From: Steven Shaw [REDACTED]
Sent: 20 April 2018 11:28
To: Claire Potts
Cc: Stephen Gee
Subject: RE: A/23/15/OUT and A/11/17/OUT

Access

Land South of A259 New Road and East of Brook Lane, Angmering, West Sussex

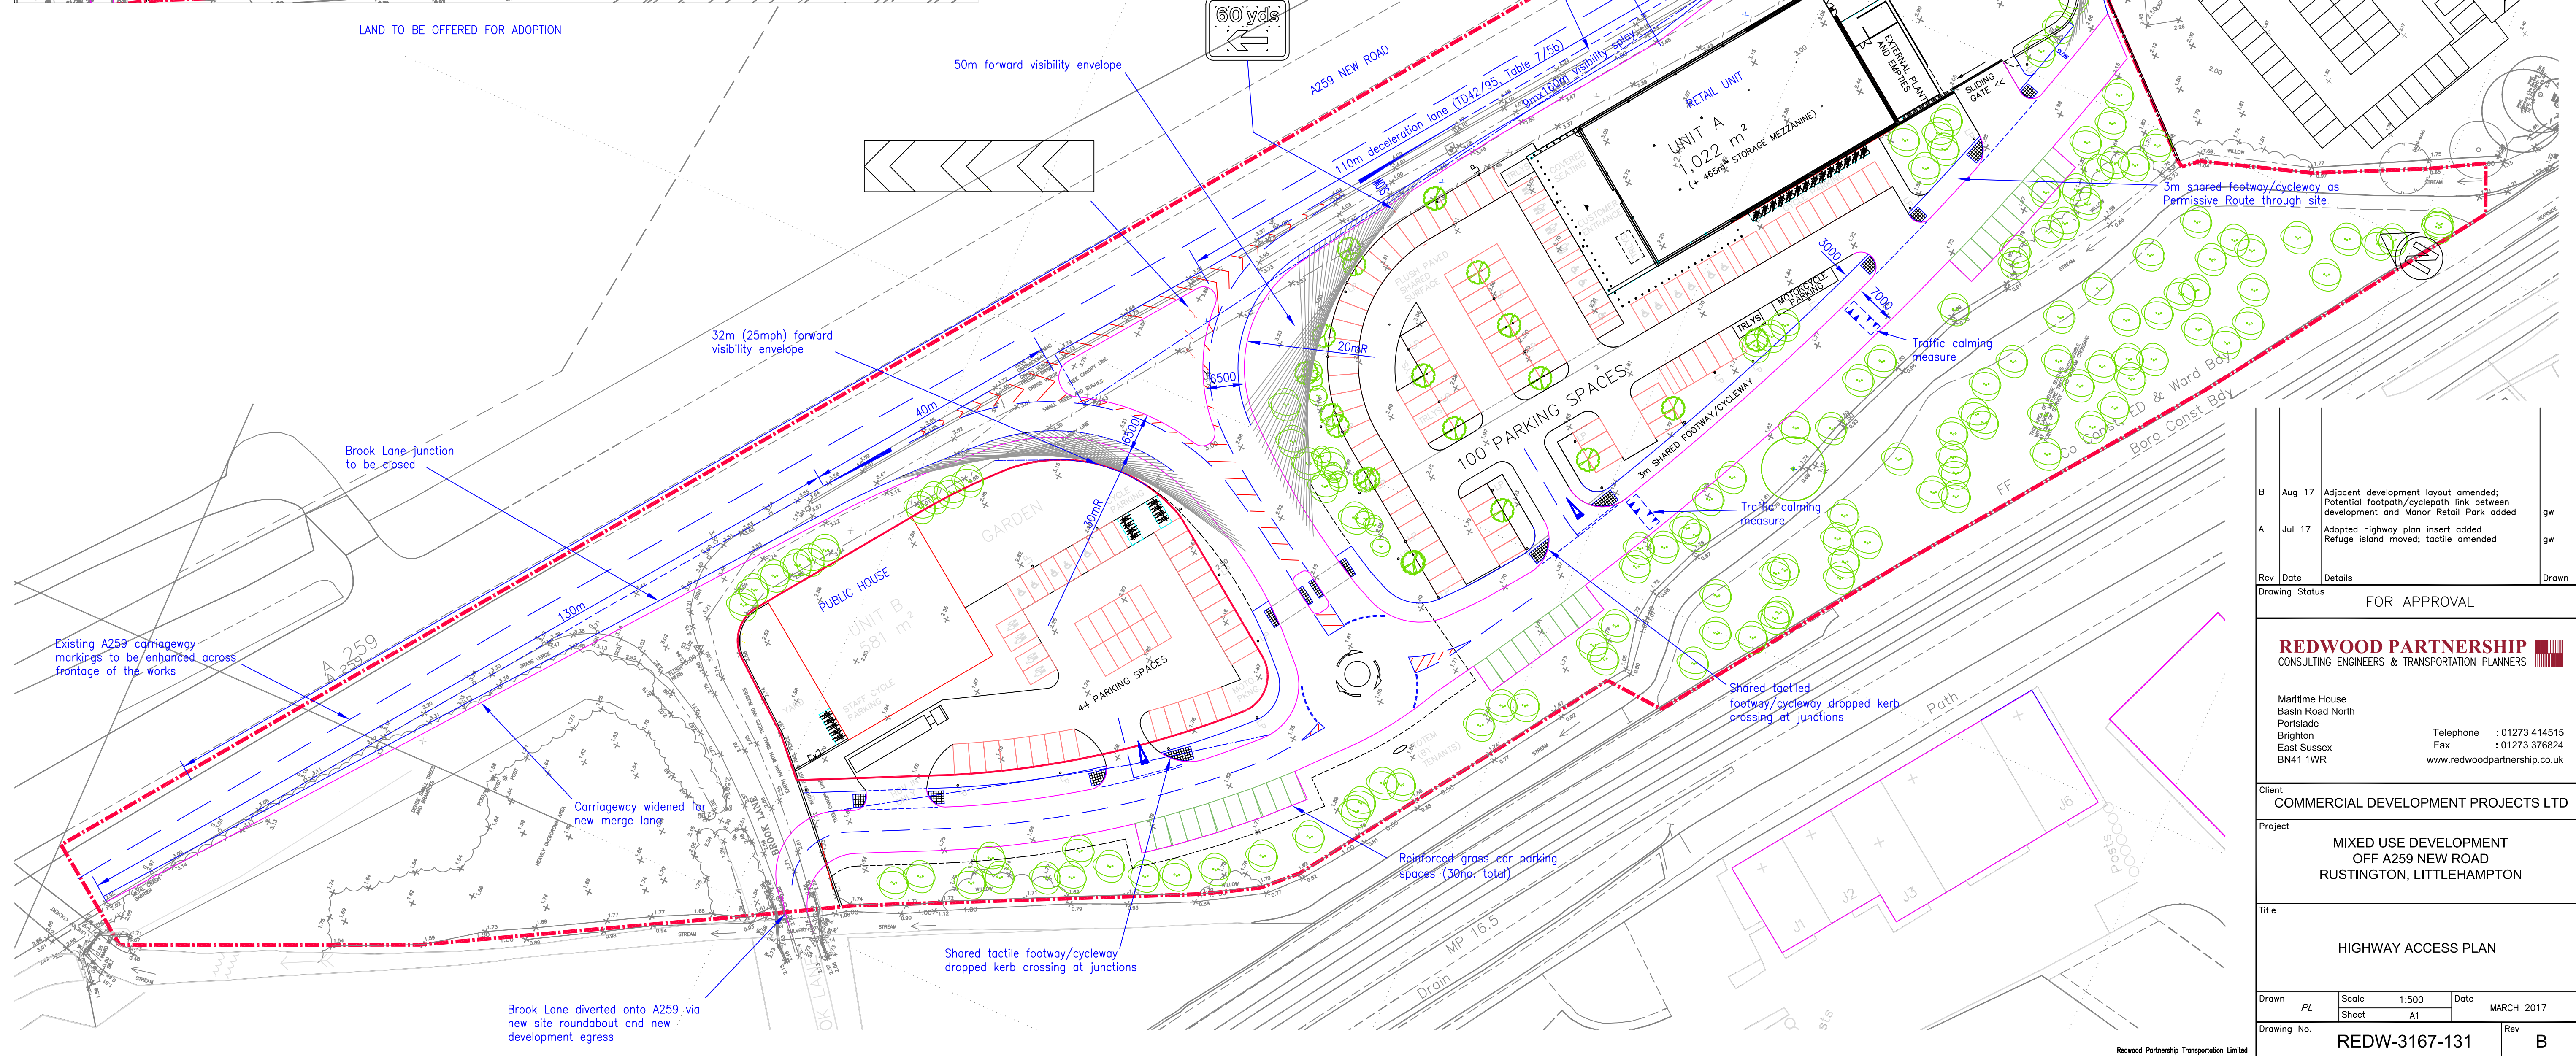
The applicant for planning applications A/11/17/OUT and A/23/15/OUT needs to demonstrate that a safe and suitable access can be provided to both their site and does not preclude access to the committed development site. At the moment they have not done this and the proposed access arrangements from both sites are conflicting. A revised drawing needs to be submitted that demonstrates how access can be provided to their site and the

adjacent. Drawing number REDW-3167-131 (Highway Access Plan) should be updated to include an overlay of the adjacent site and demonstrate how a safe and appropriate access could be provided to the adjacent site.

Access rights are a private matter and not for consideration at planning stage but what we can consider is that the applicant has failed to demonstrate that it does not preclude another committed development coming forward. Essentially, both land owners need to work together. It is also noted that the reserved matters application for A/169/17/OUT has now been submitted and will be a material consideration. Stephen Gee is considering this application and we are obviously both aware of each other's applications.
